**CITY OF MERCER ISLAND**

March 15, 2018

RE: Review Comments for File No. CAO17-010 – Hou Critical Areas Determination  
4825 E Mercer Way, Mercer Island, WA 98040; King County Tax Parcel # 216200-0070

**CRITICAL AREAS MITIGATION PLAN
 PROPOSED SITE PLAN, IMPACTS & MITIGATION PLAN
 HOU PROPERTY
 MERCER ISLAND, WA**

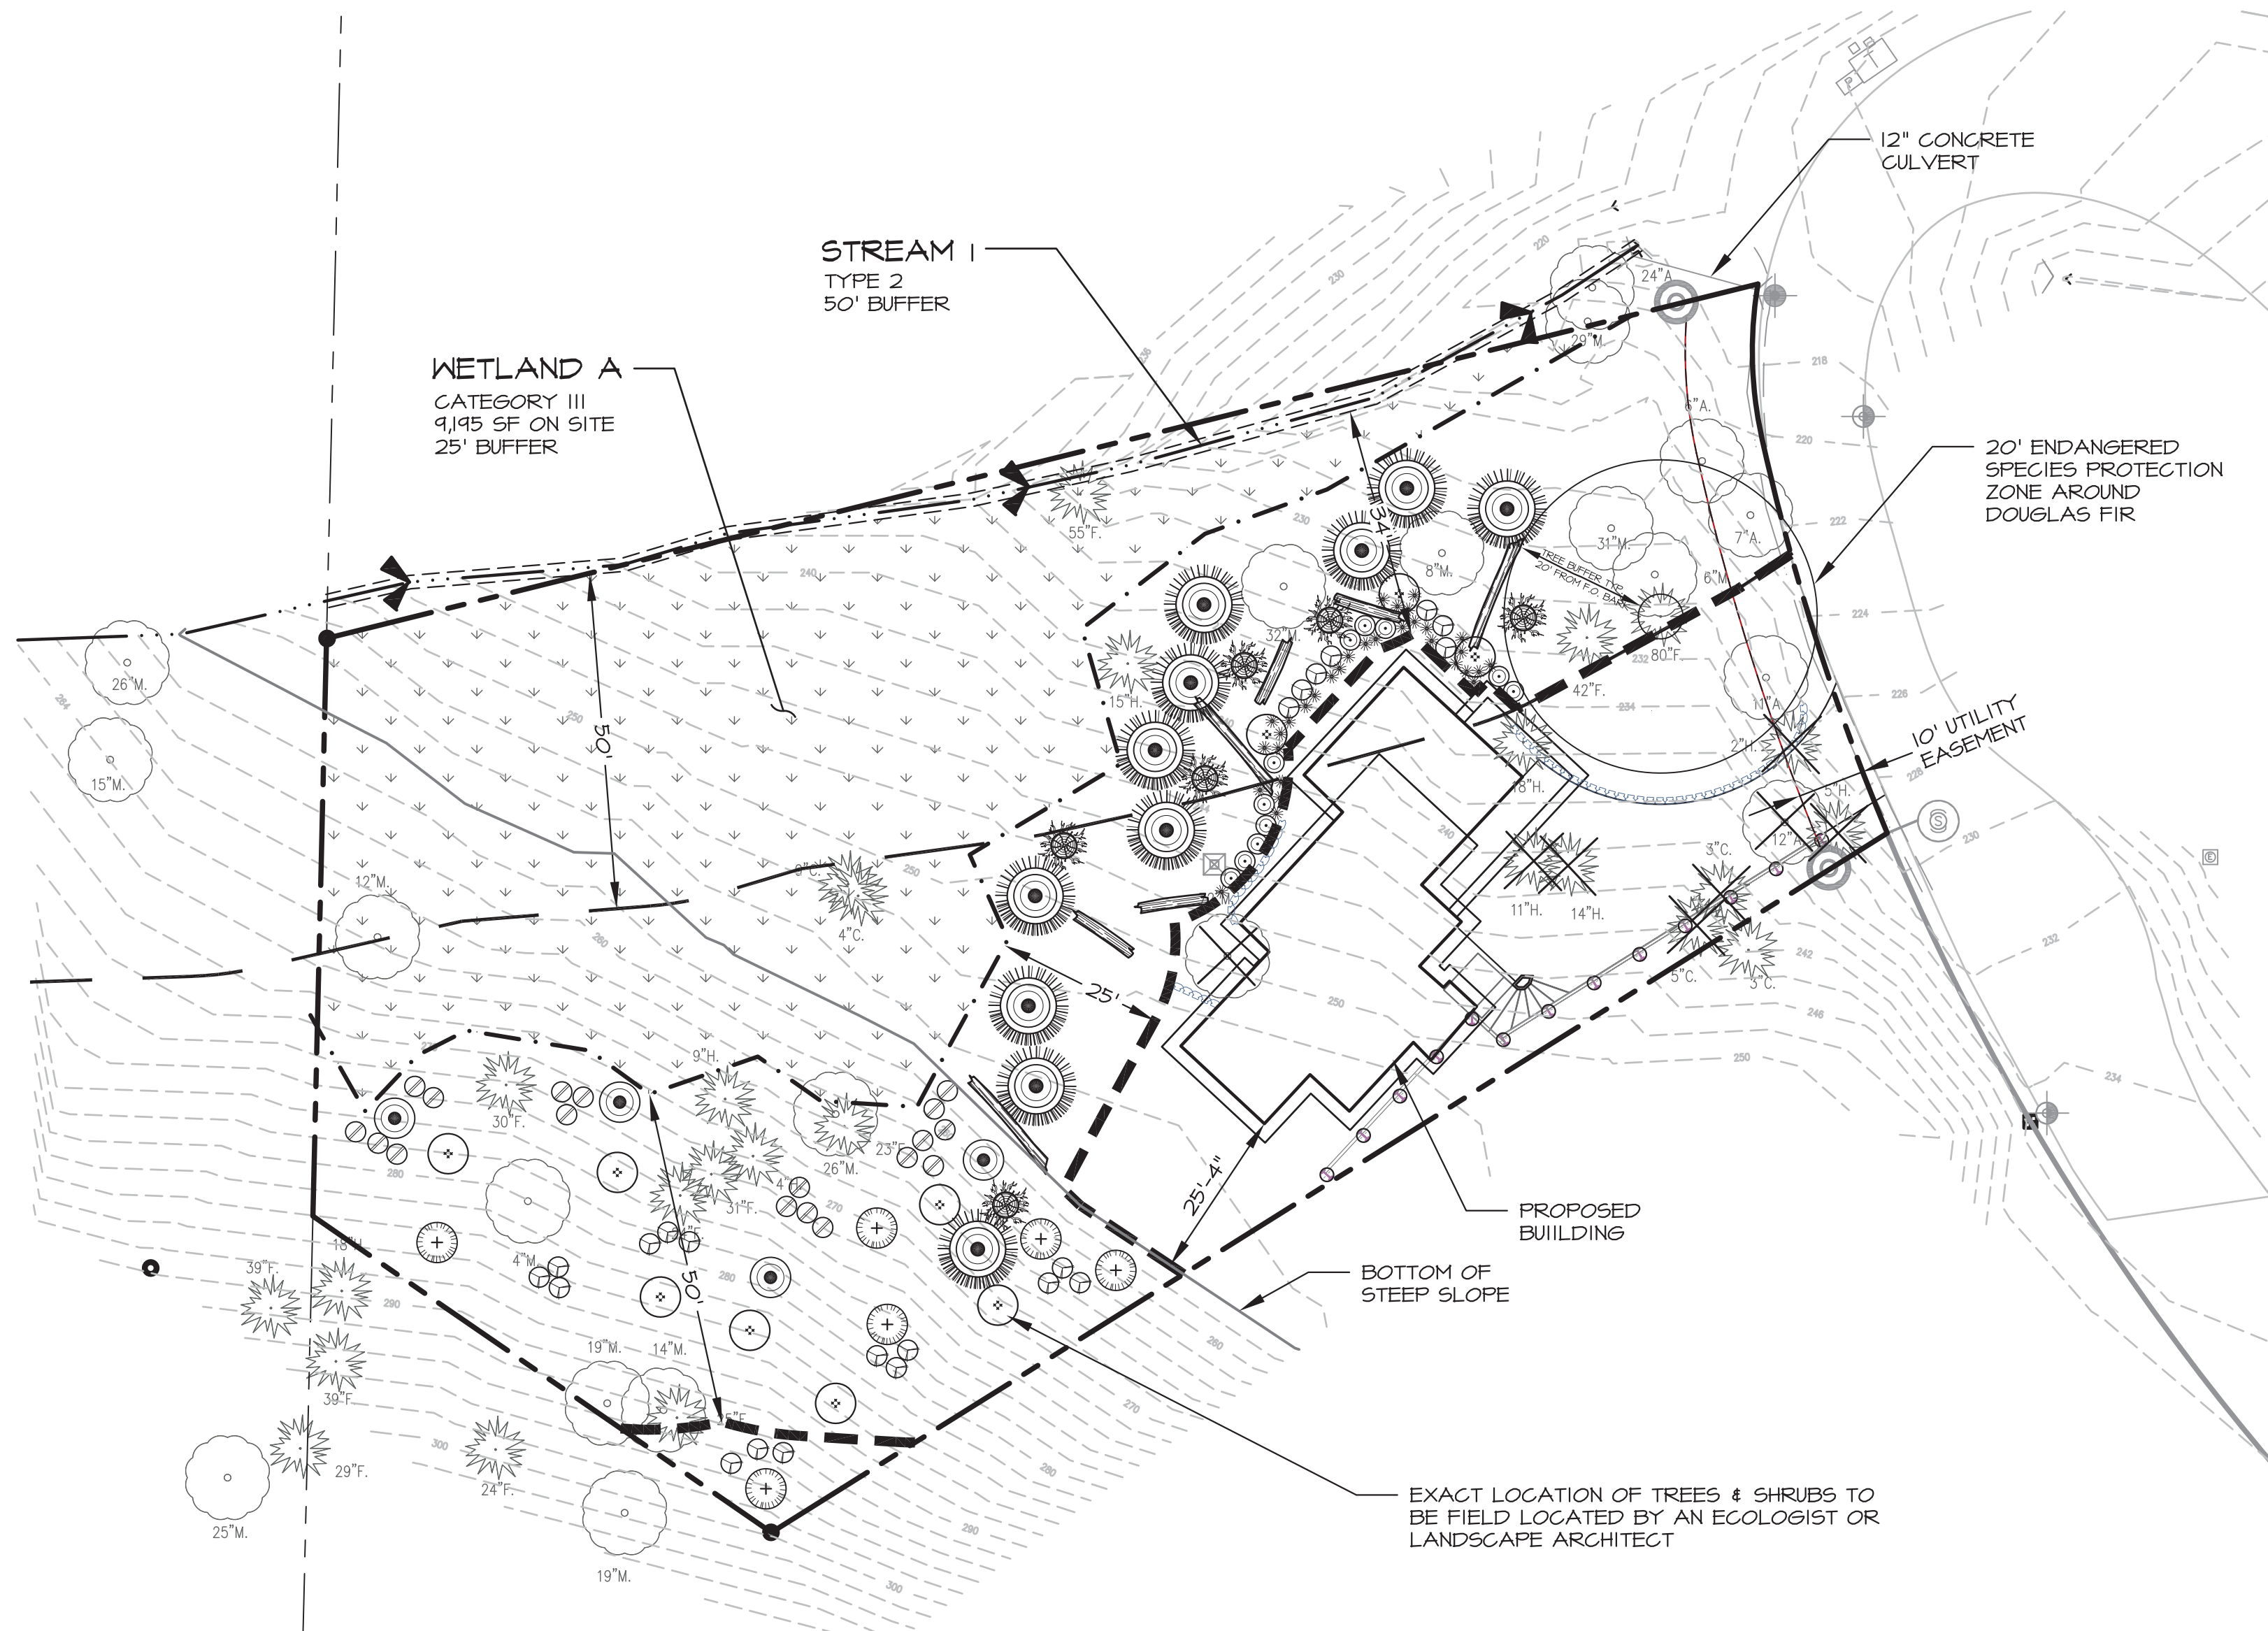
1. Please submit a revised site plans that shows a building pad pursuant to MICC 19.09.090(B). MICC 19.09.090(A)(1)(a) states that building pads shall be located to minimize or prevent impacts to trees and vegetation required for retention.

Please revised the “proposed buildable area” on the site/mitigation plans to reflect the building pad area for the proposed residence. Please ensure the building pad is not located within the dripline of the 80-inch and 42-inch firs, and any trees that are required for retention (e.g. trees located within critical areas and critical are buffers).
